Re: MMC Staff Parking Garage | 222 St. John Street | Level III Site Plan Design Change

The purpose of this memorandum is to summaraze changes made within the attached revised design drawings since the initial Level III Site Plan Submission on June 22, 2018.

WEST ELEVATION
 1/16" = 1'-0"

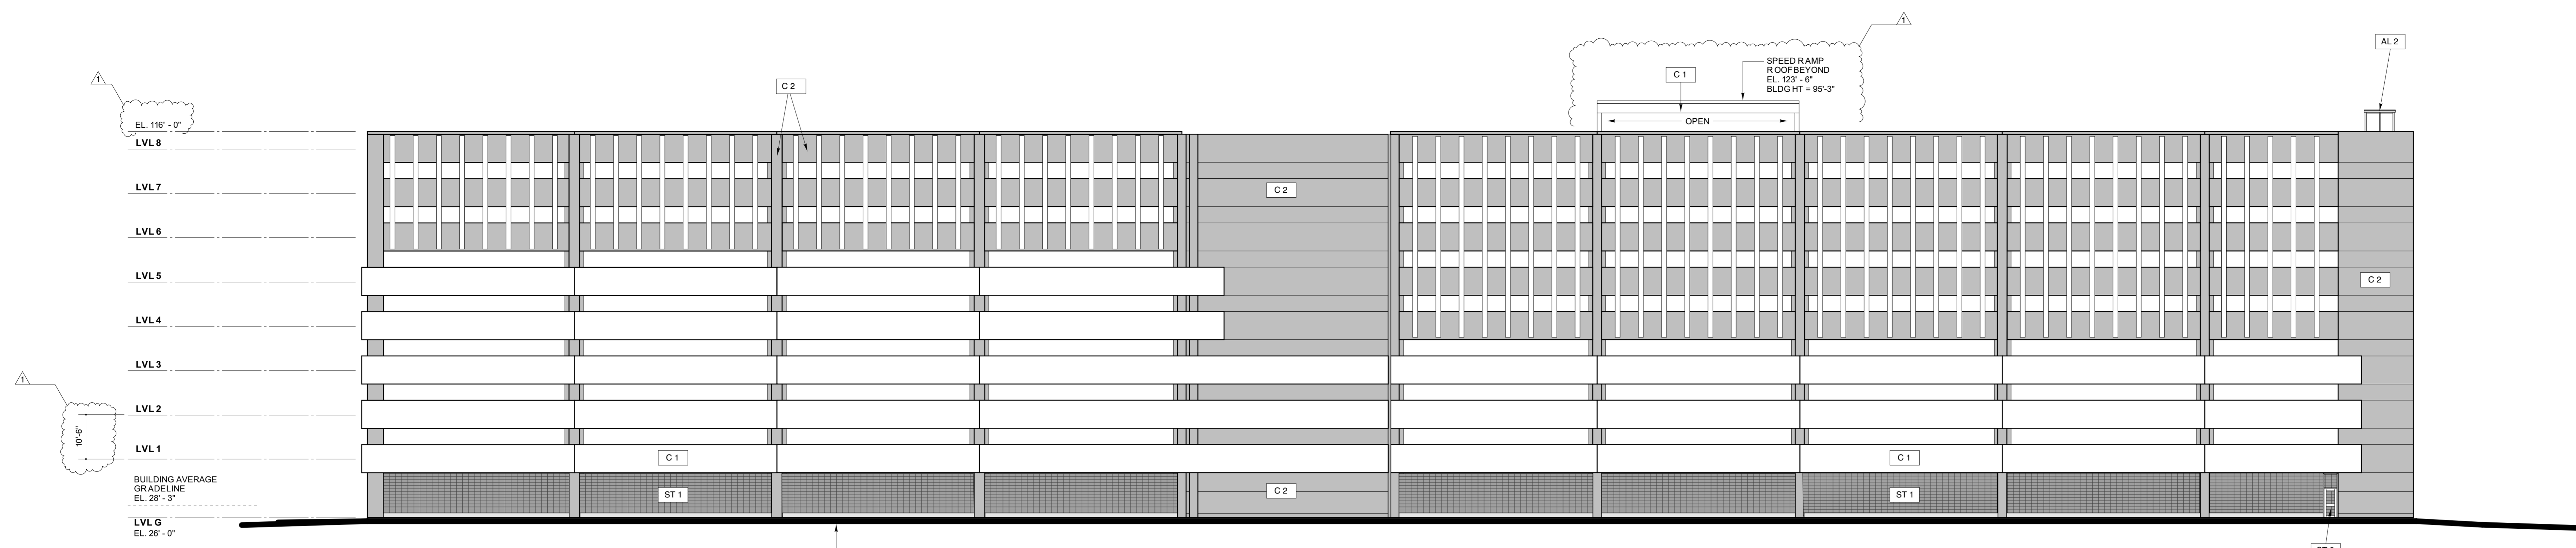
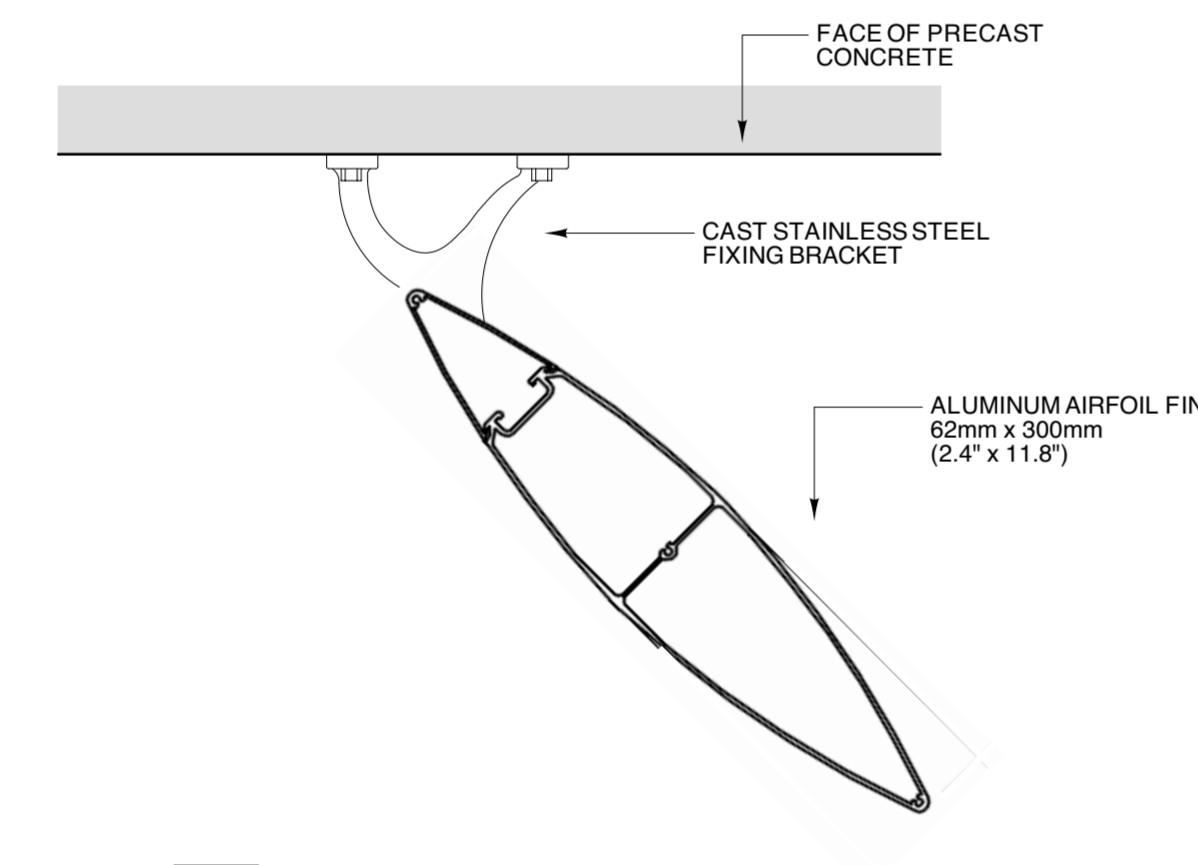
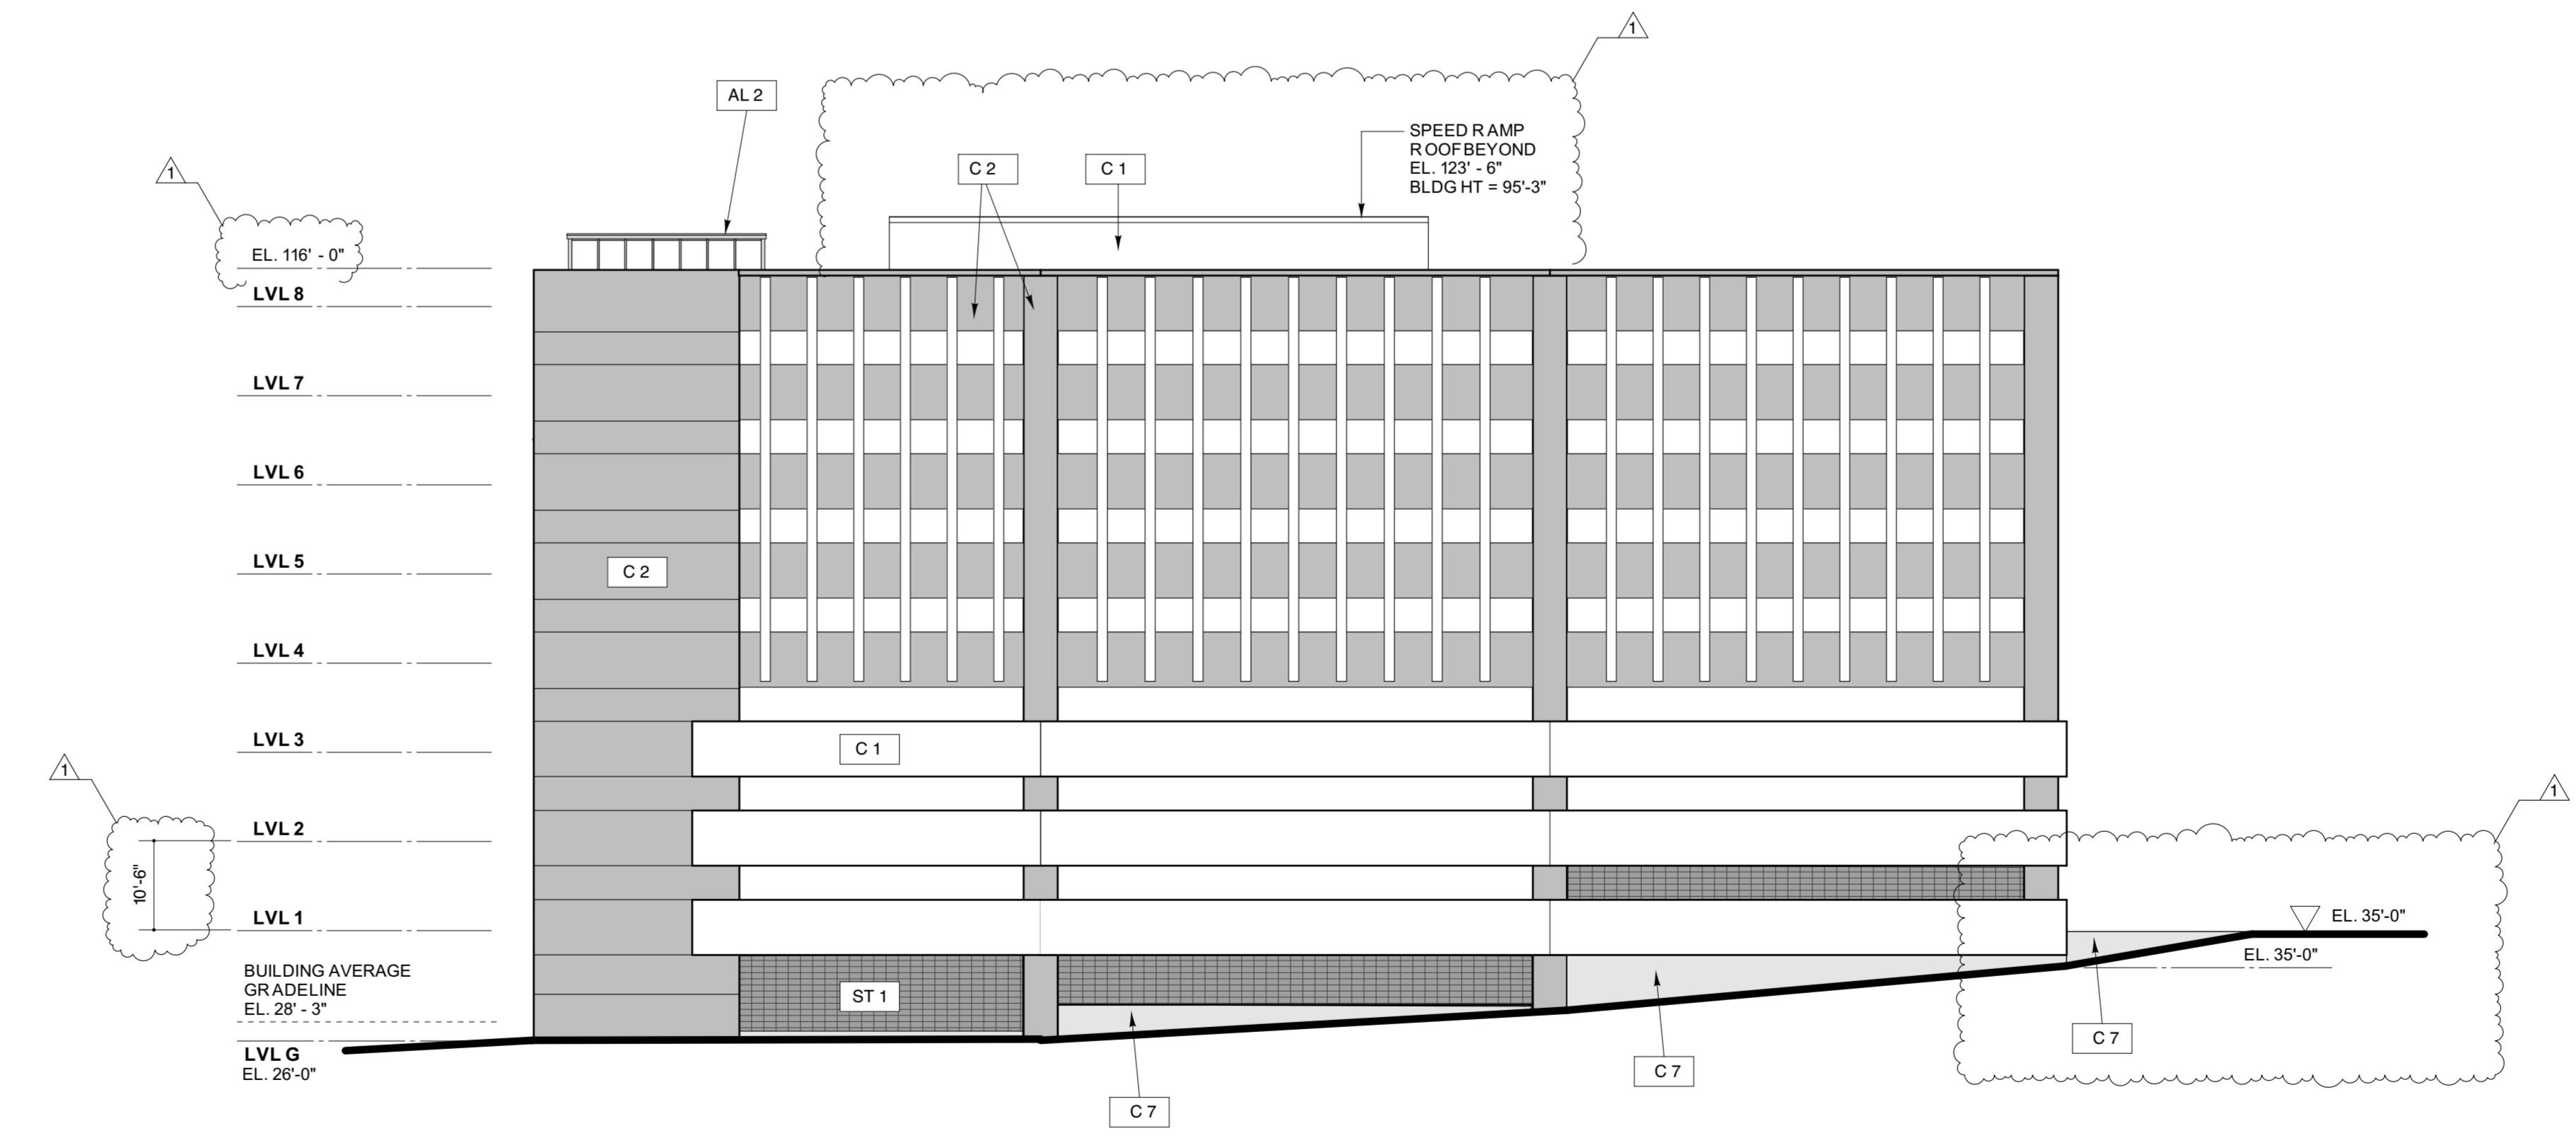
- Revised east façade to accommodate entrance for 184 St. John Street users (Eagles).
- Enlarged canopy over entrance area in response to City comments.
- Added windows at electrical / mechanical rooms in response to City comments.
- Reduced the floor to floor height of the first deck level (lower) by relocating van accessible spaces to level G; revision resulted in a reduction in the overall building height (revisions to elevation call outs)
- Removed the screening wall above the stair tower due to changes in mechanical equipment
